DEVELOPMENT REVIEW BOARD

Planning Dept. - Major Case Comments

Project Number: PR-2019-002496

Project Name: Alameda Barstow Apartments

1. ANY BUILDING MOUNTED SIGNAGE IS TO BE ACHIEVED THROUGH A SEPERATE BUILDING PERMIT IN ACCORDANCE WITH THE UNDERLYING MX-1 ZONING

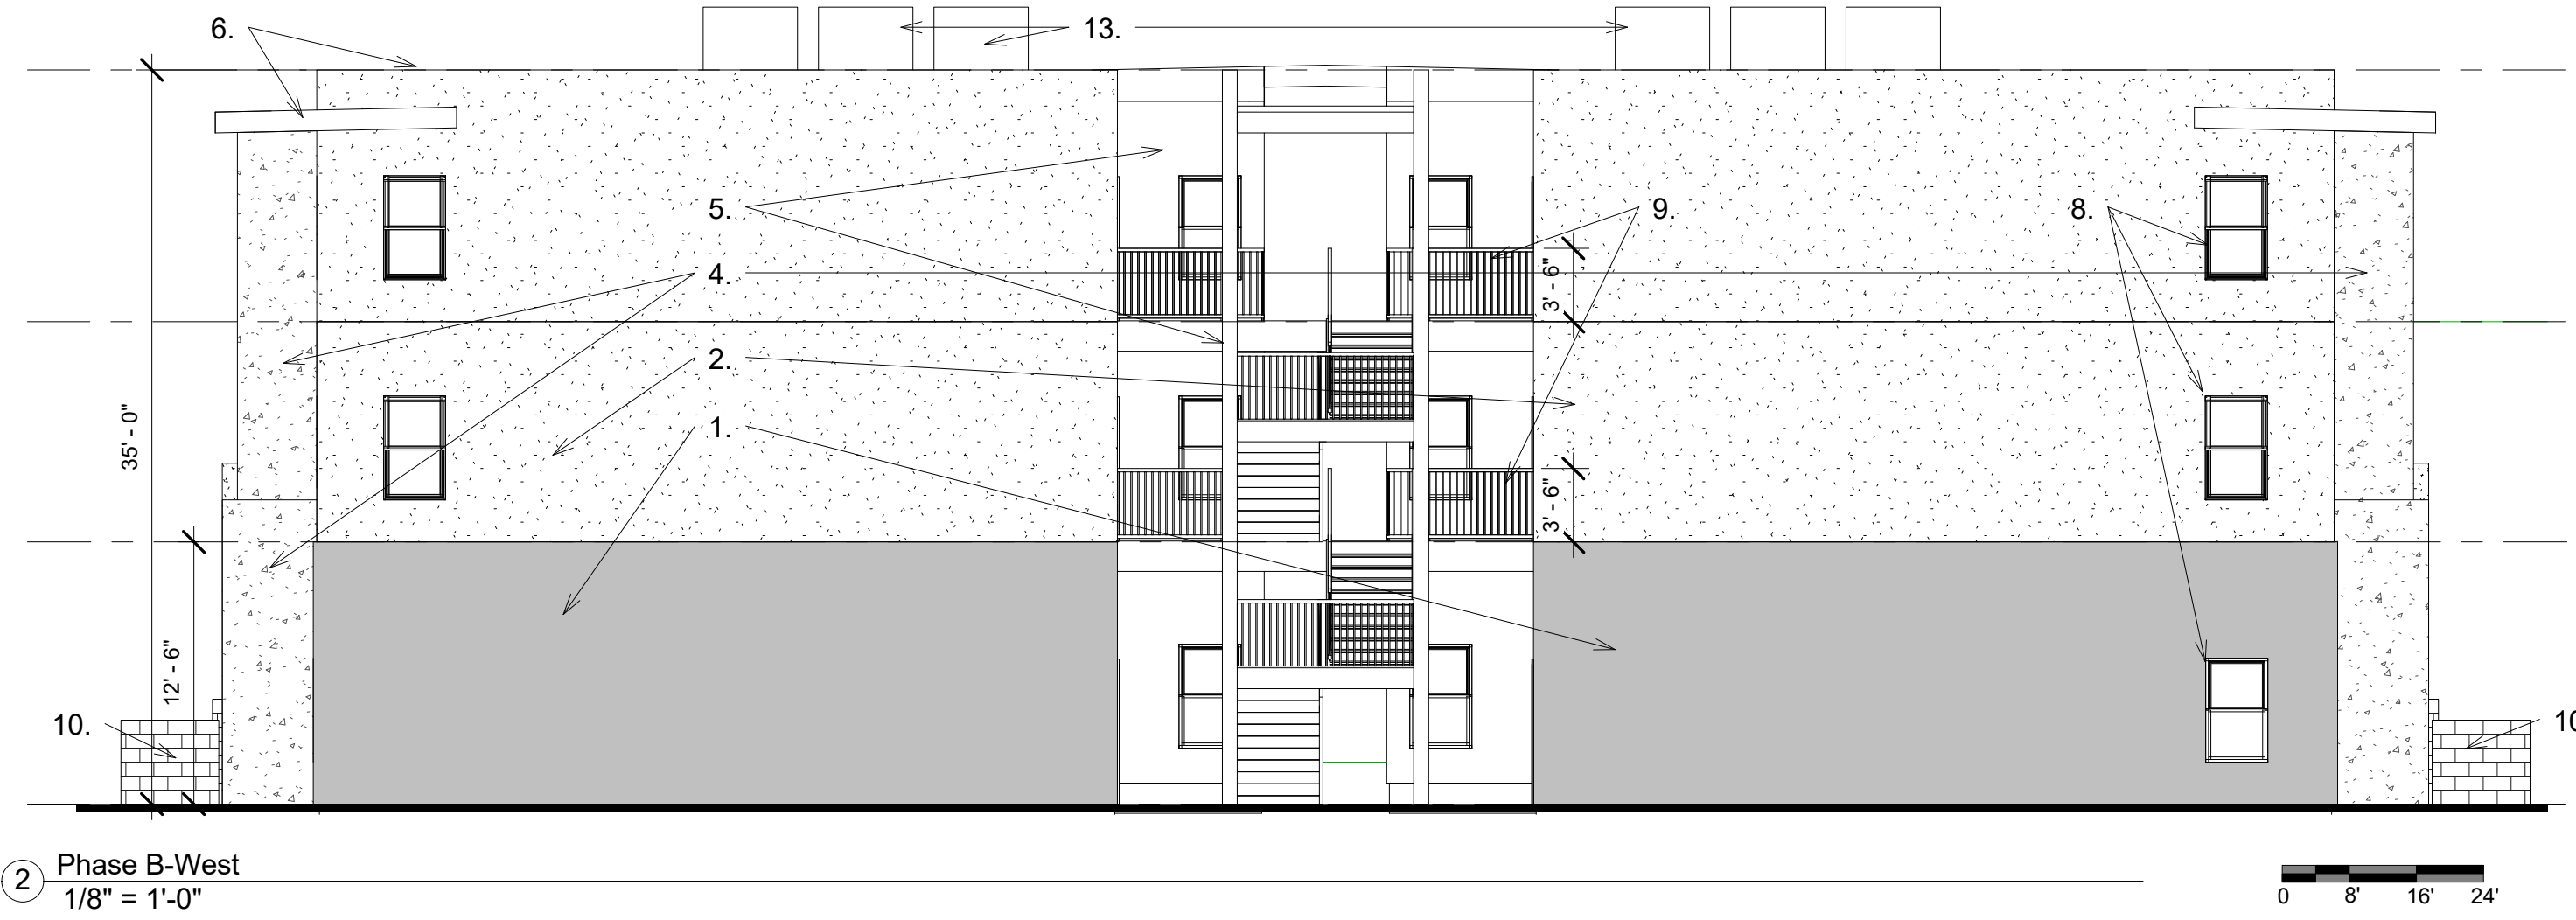
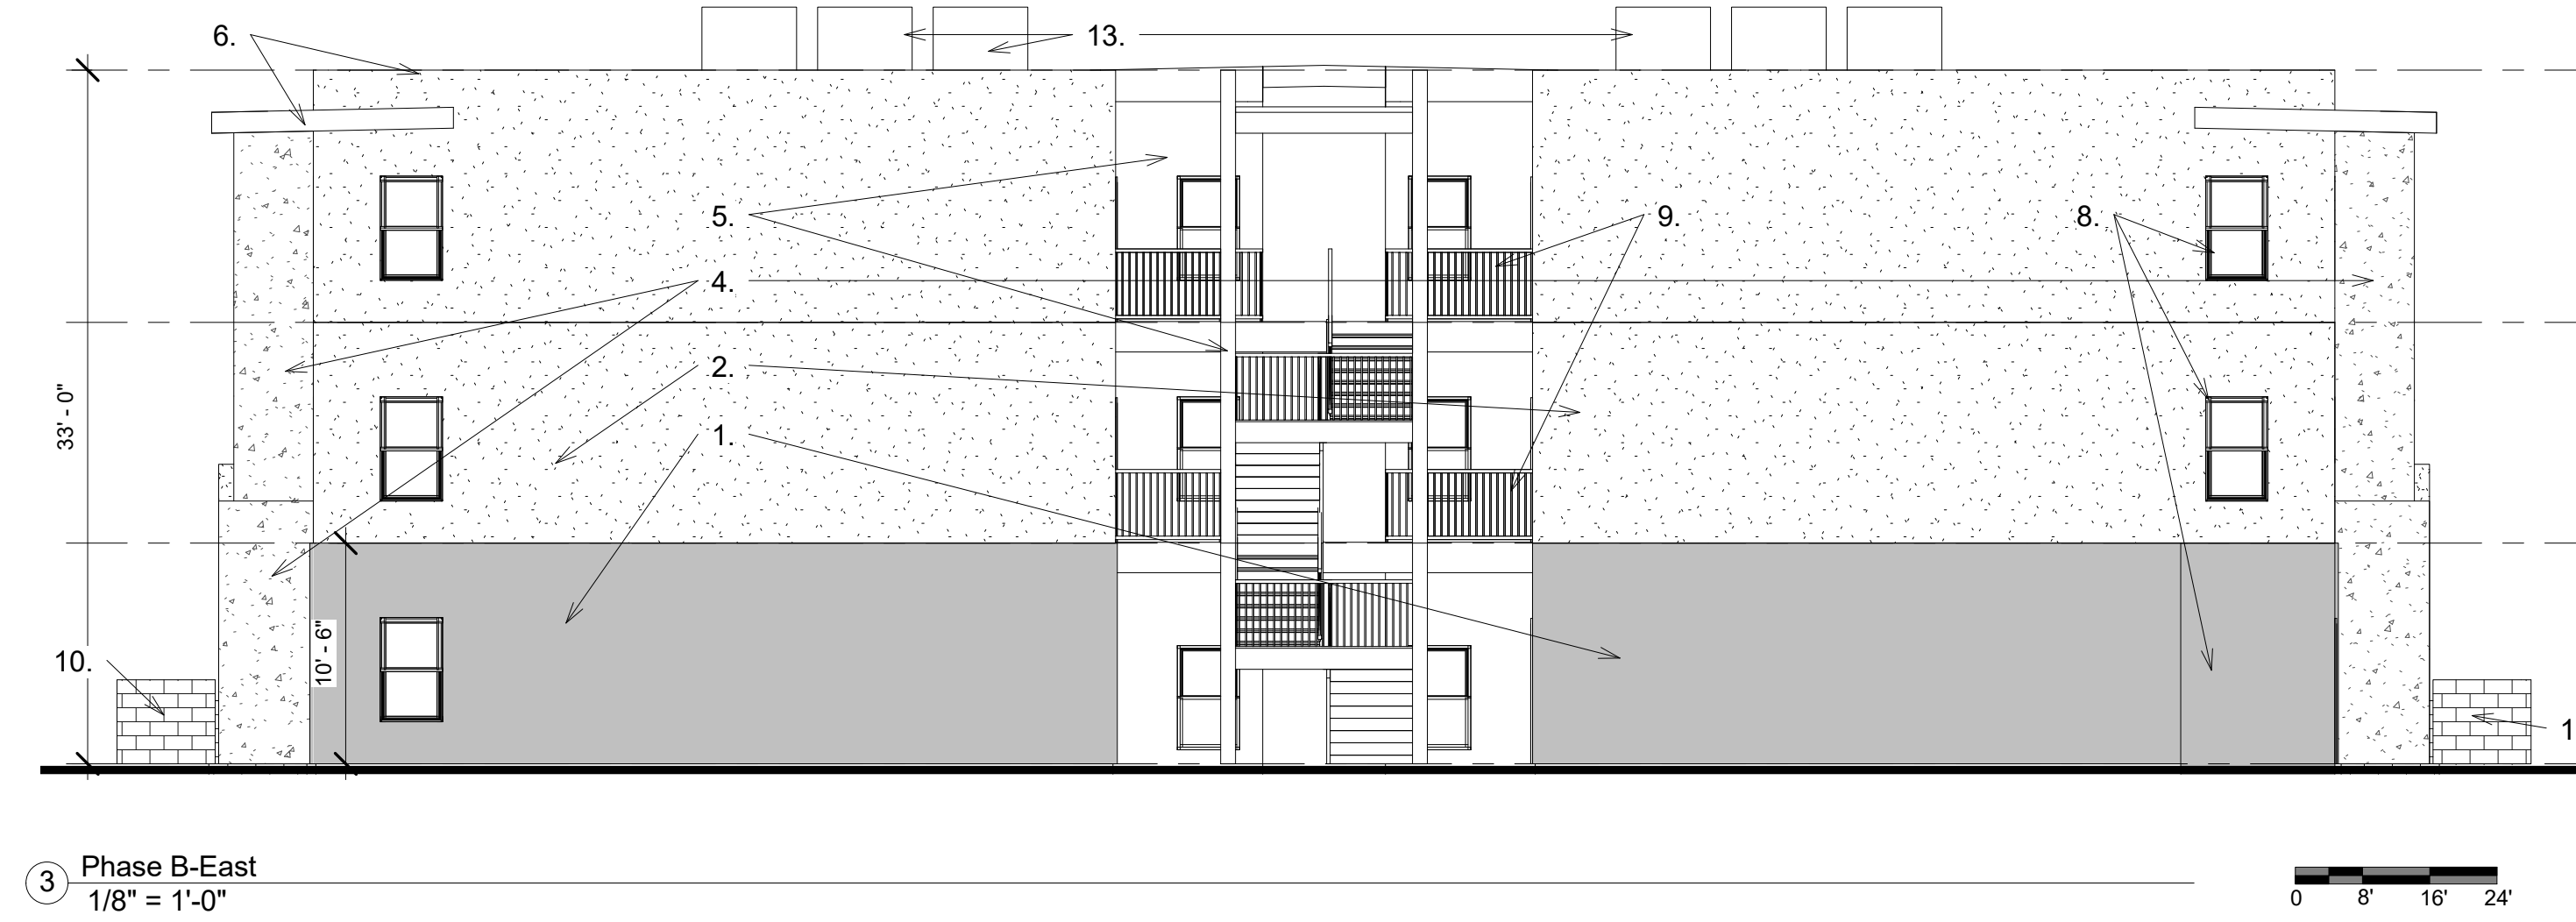
1. We need more information on the lime green structures/features (as to what they are). These are shown on the color rendering.
2. The standards in 5-11 require that each façade facing a public street shall incorporate at least 2 of the following features along at least 30 percent of the horizontal length of the façade. The features listed below shall be distributed along the façade so that each horizontal façade length of 40 linear feet contains at least 1 of the following features: Please clarify the percentage of windows along the horizontal length.
3. Please clarify the roofline- the color rendering appears to show variation, the elevations do not.
4. Please clarify the building and phasing labels- buildings are labeled as phases.
5. Clarify the identity of what is being constructed in the open space.
